January 20, 2022

Re: Brio Sandia Apartment
11930 Menaul Blvd. NE
Traffic Circulation Layout
Architect's Stamp 12-17-21 (H22-D029)

Based upon the information provided in your submittal received 01-14-22, the above referenced plan cannot be approved for Building Permit until the following comments are addressed:

AS101

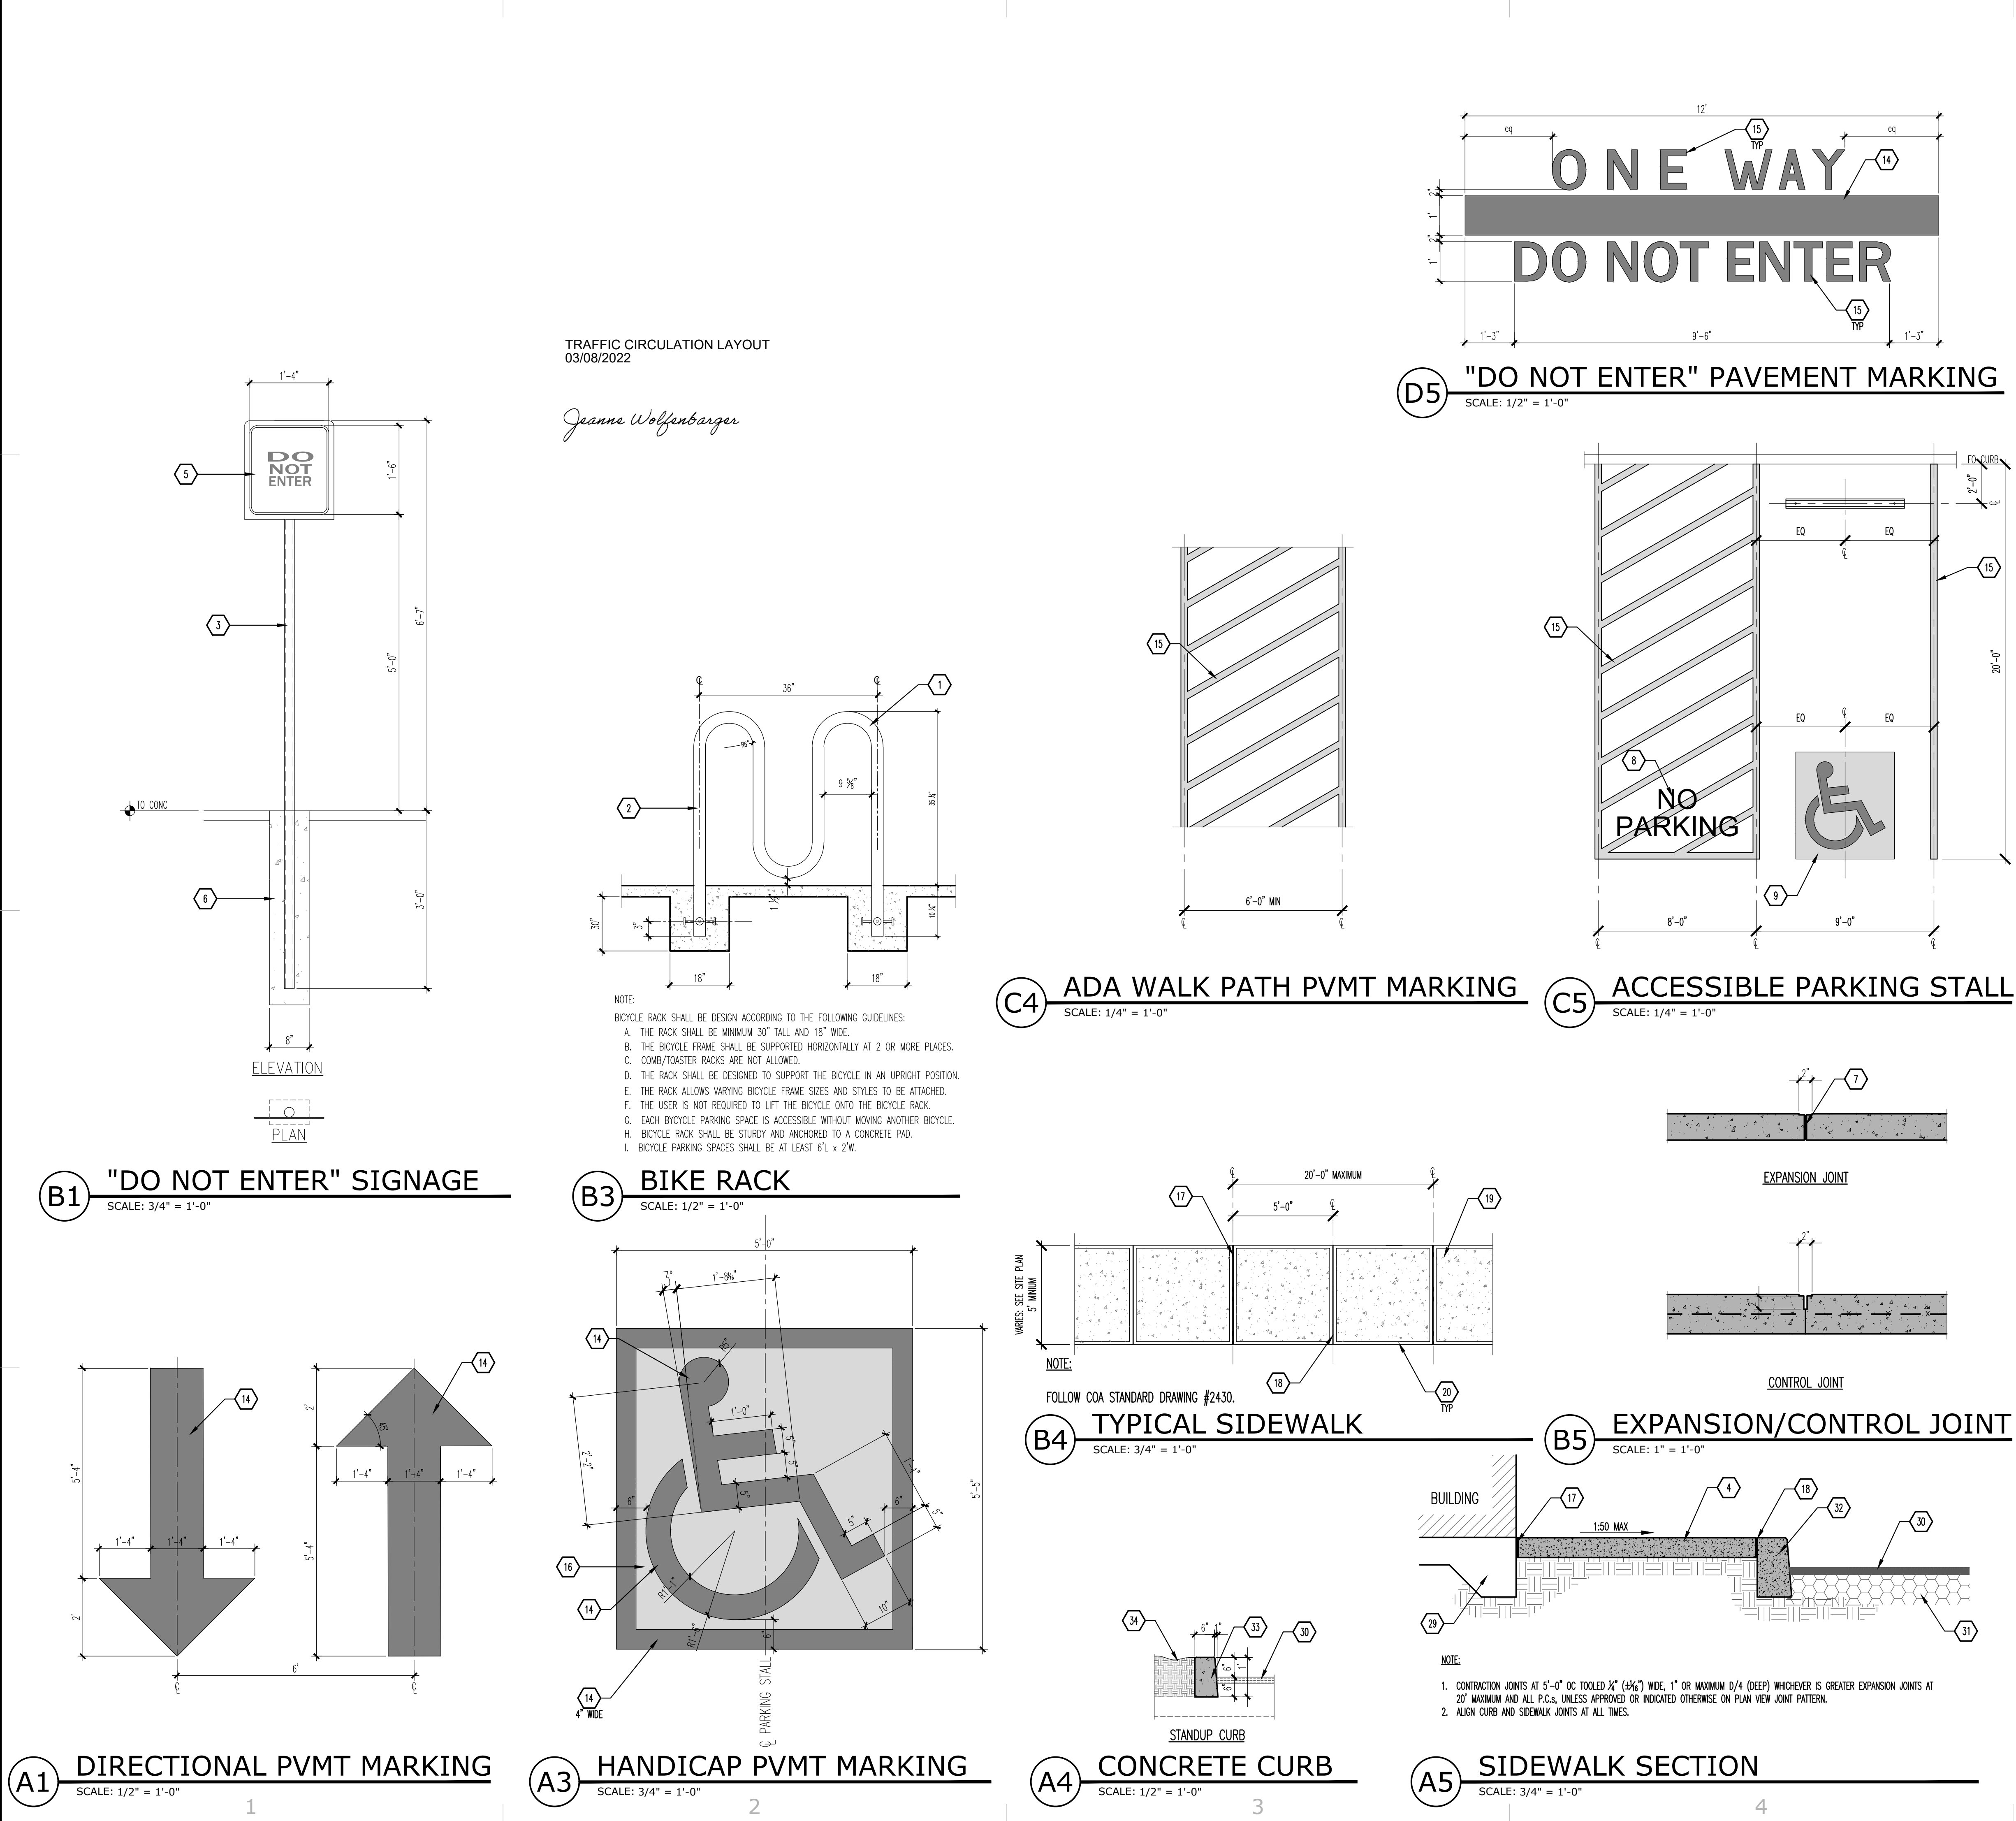
1. Provide width for the both existing drive pad entrance.
2. Maximum access width for arterial, collector, and local streets are as follows:

3. According to your parking calculation, you didn't provide 4 ADA parking spaces, Motorcycle parking spaces, and Bicycle racks. Please provide all required parking spaces.

4. Per DPM, a 6 ft. wide ADA accessible pedestrian pathway is required from EACH ADA parking stall access aisles to the building entrances. Please clearly show this pathway and provide details.

10. All one-way drives shall have "One Way" and "Do Not Enter" signage and pavement markings. Please show detail and location of posted signs and striping.

11. Provide face sign details for Motorcycle and for "DO NOT ENTER" sign.
 12. Add a note stating "All broken or cracked sidewalk must be replaced with sidewalk and curb & gutter." A build note must be provided referring to the appropriate City Standard drawing.

B3 MOTOR CYCLE SIGN
SCALE: 3/4" = 1'-0"

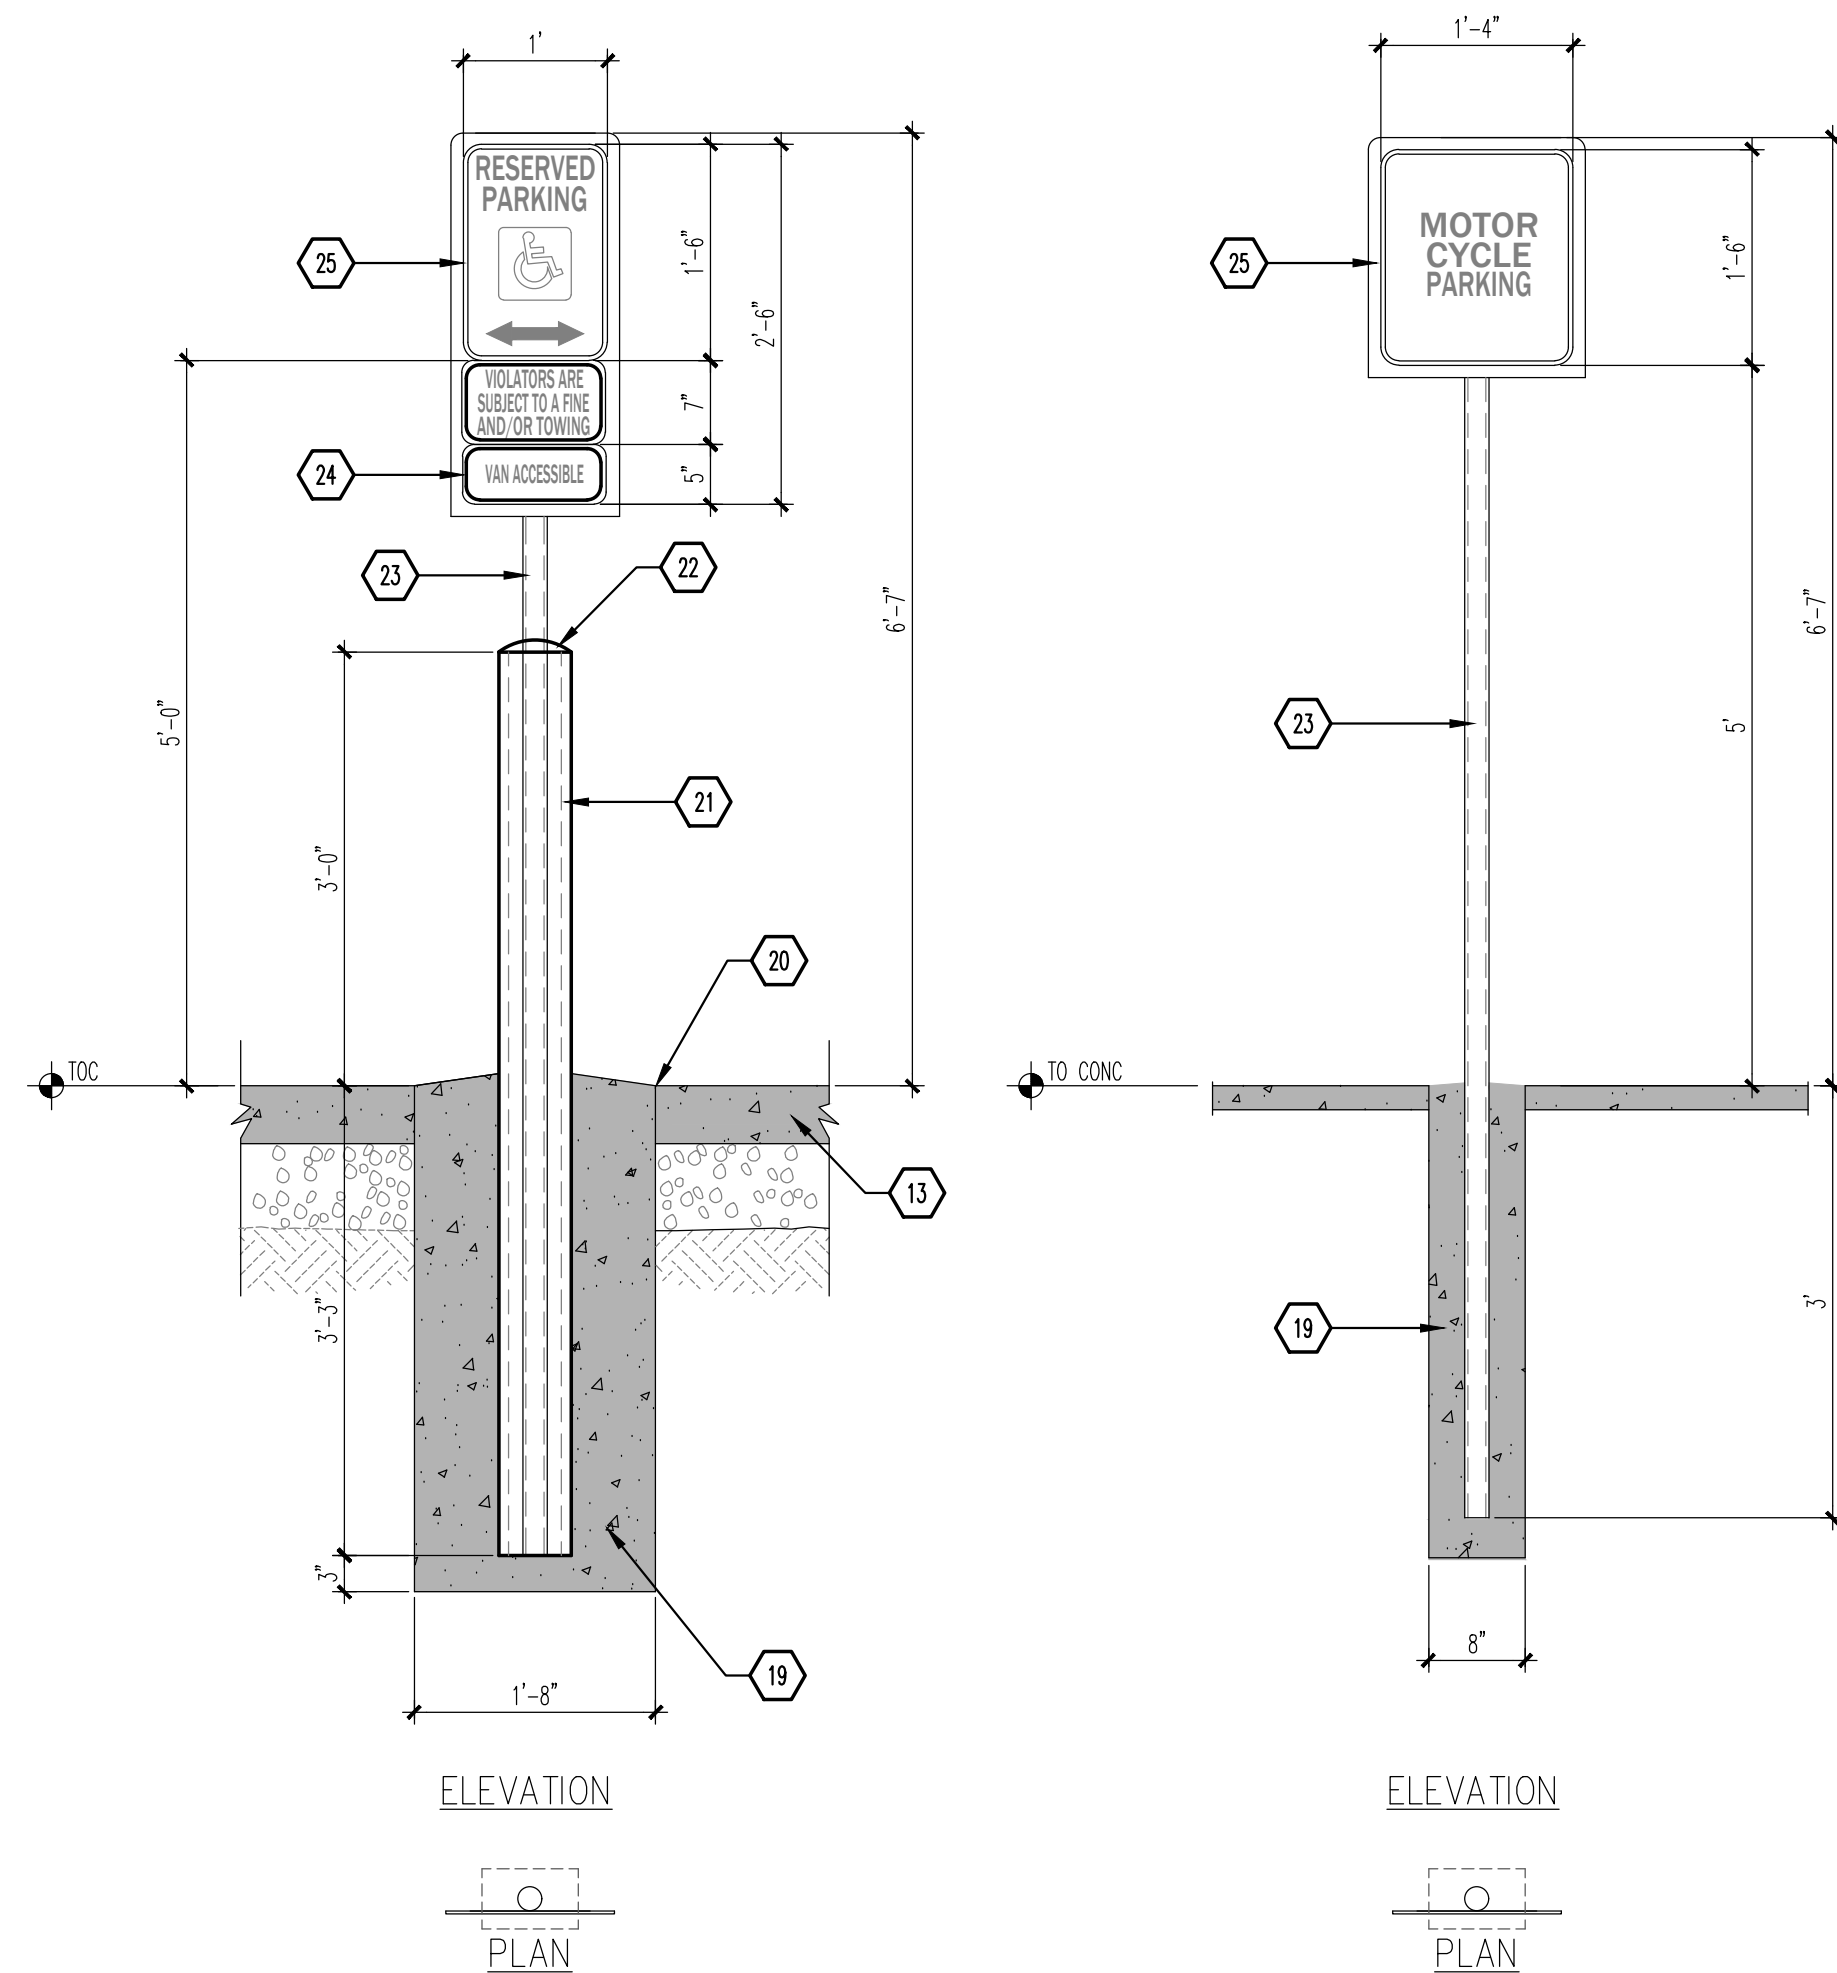
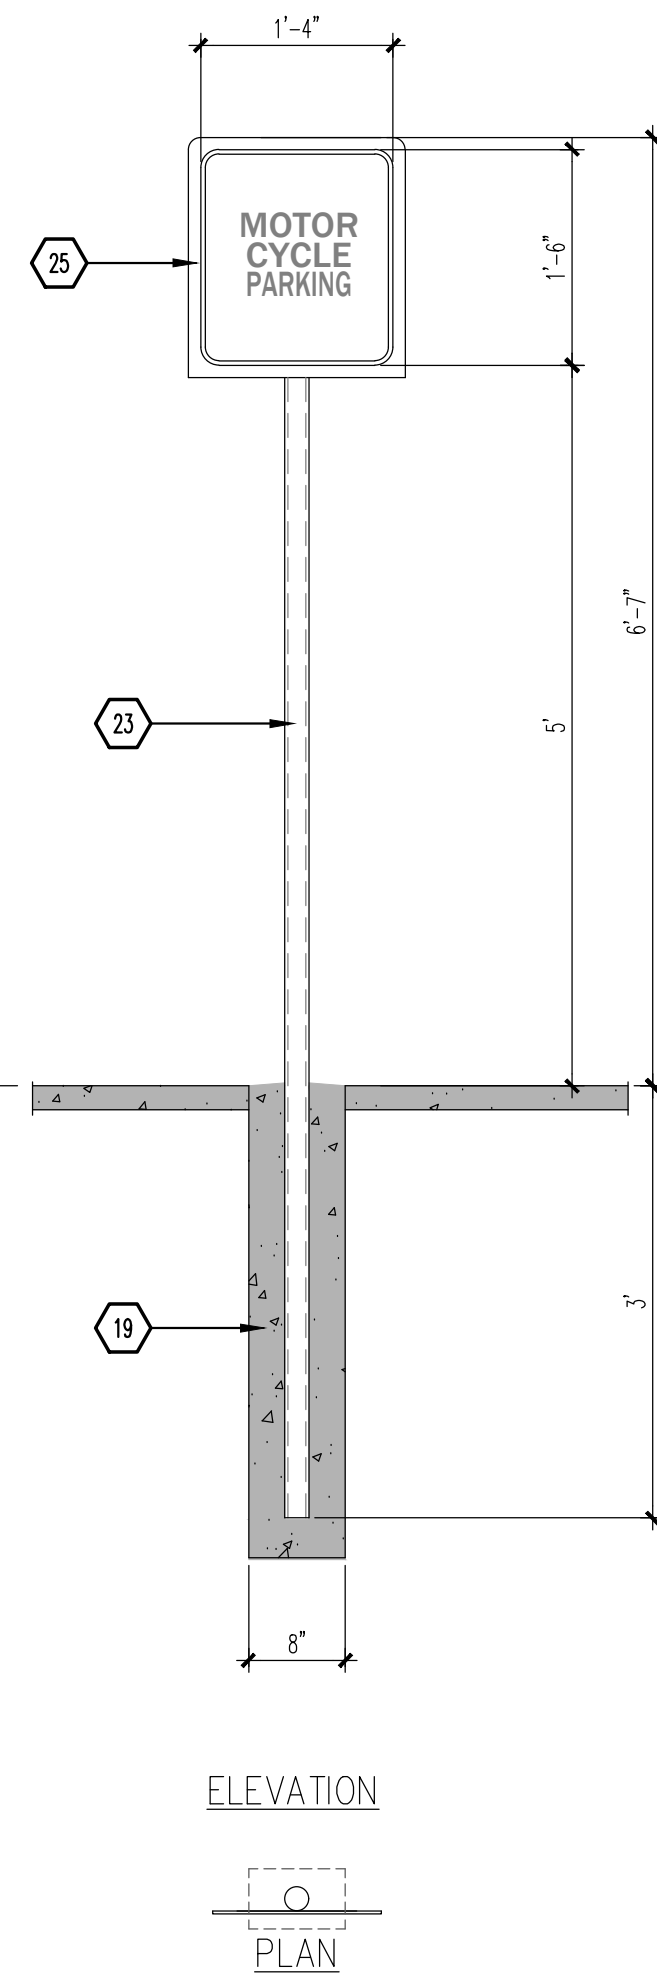
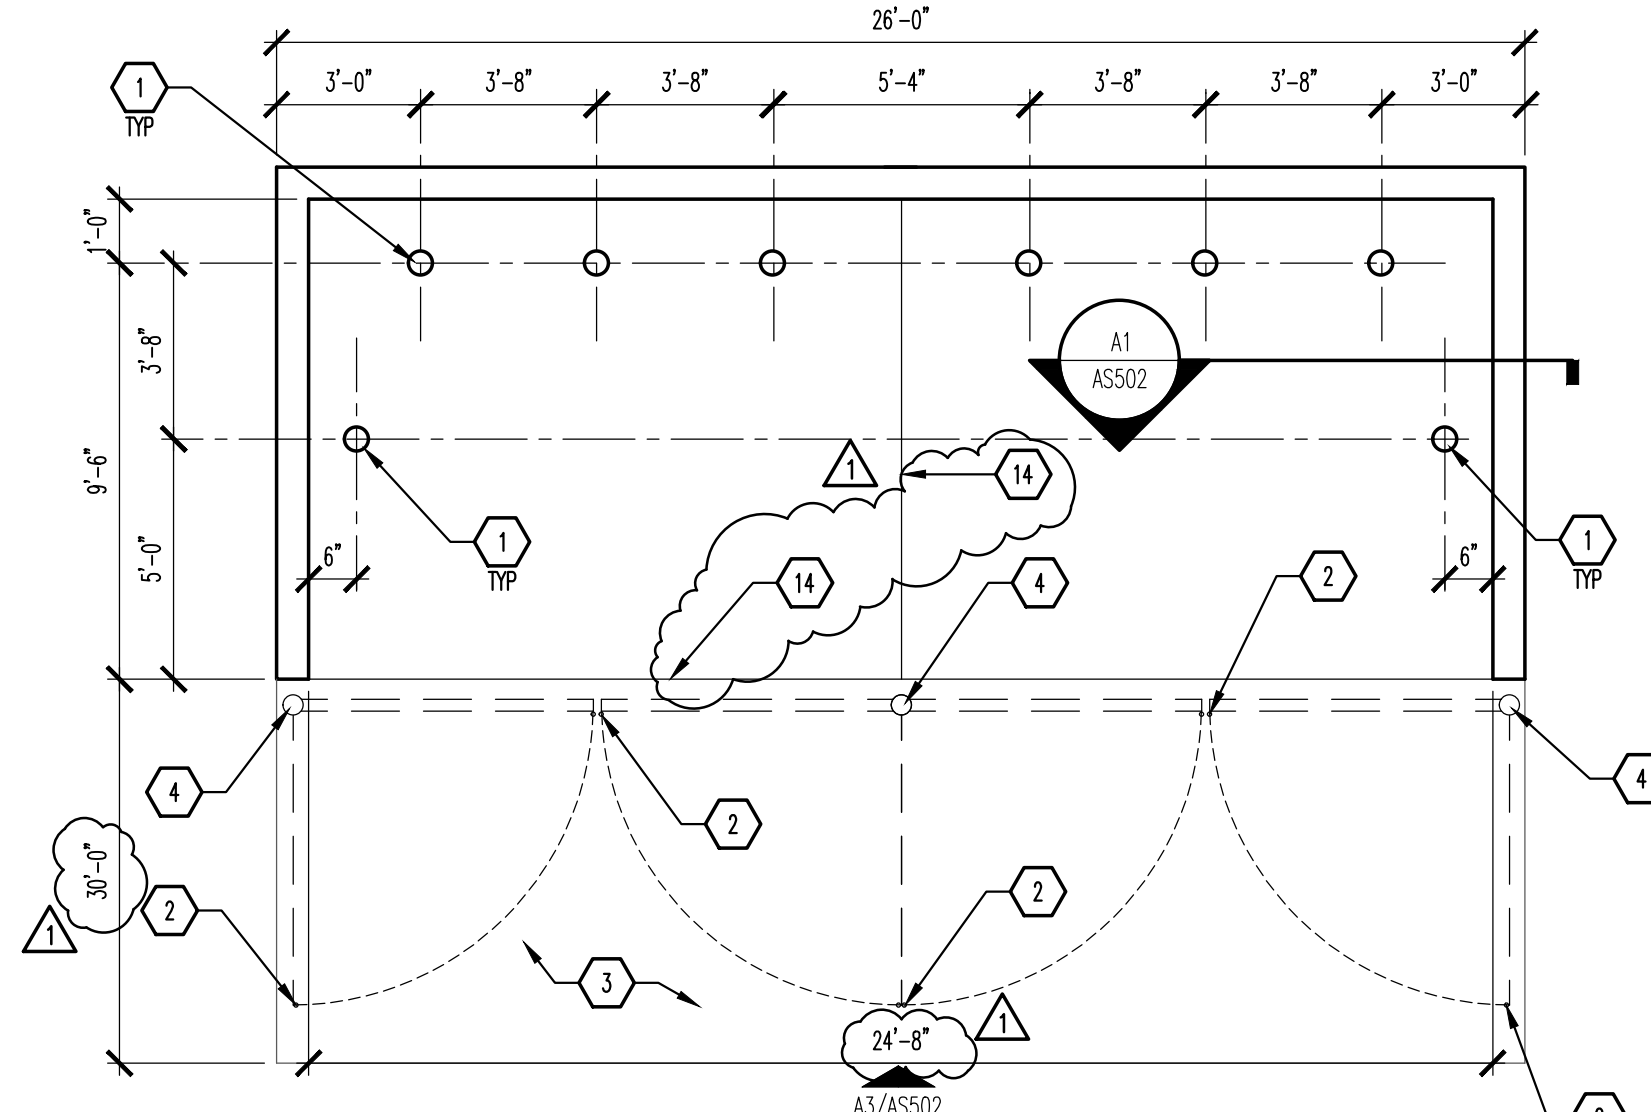
5. Motorcycle parking spaces shall be designated by its own conspicuously posted upright sign, either free-standing or wall mounted per the zoning code.
